From: Paul Cann
Sent: 15 May 2017 11:31
To: Planning.Responses
Subject: RE: Planning Consultation on AB/56/17/DOC

NOTIFICATION FROM ARUN DISTRICT COUNCIL
TOWN AND COUNTRY PLANNING ACT 1990
APPLICATION AB/56/17/DOC

Registered: 04-MAY-17
Site Address: 15 Queens Lane Arundel BN18 9JW

Description of Works: Application for approval of details reserved by condition no 5 imposed on planning reference AB/14/16/PL relating to surface water drainage

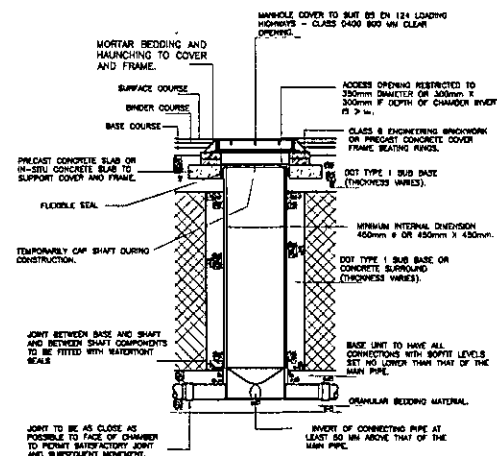
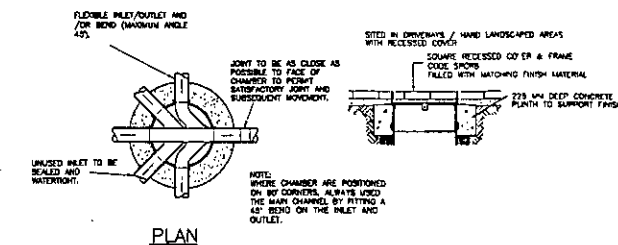
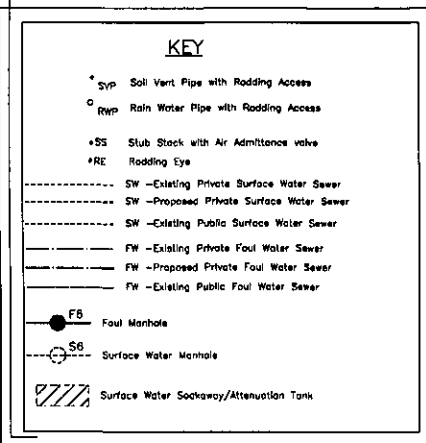
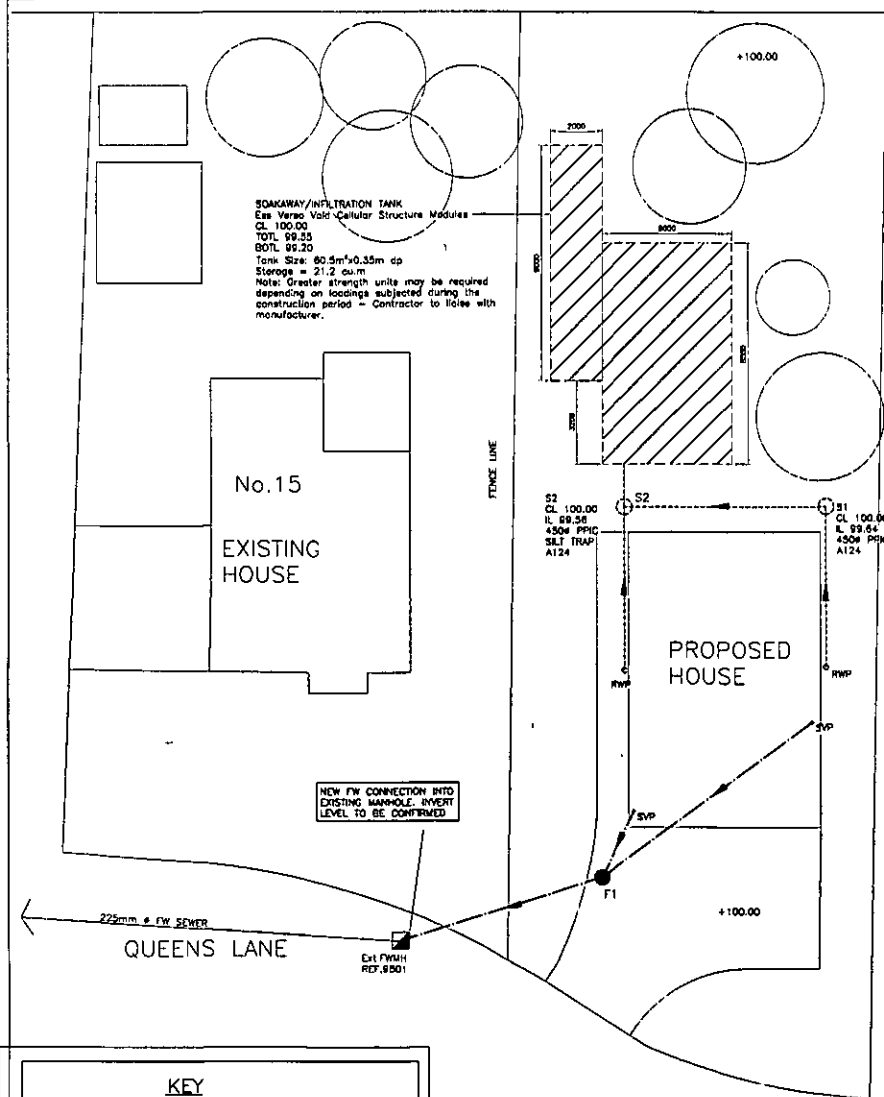
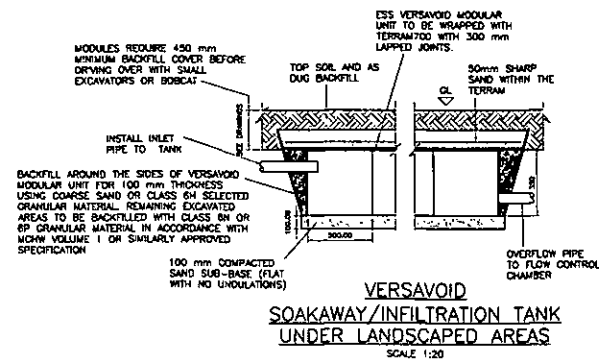
The principle has been agreed by my former colleague, Tom Callaway, however the construction detail (cross section) for the crated soakaway needs to be representative of what is proposed. I.e. no overflow pipe, specify pipe inlet levels, soakaway base levels, pipe diameter, crate depth, etc.
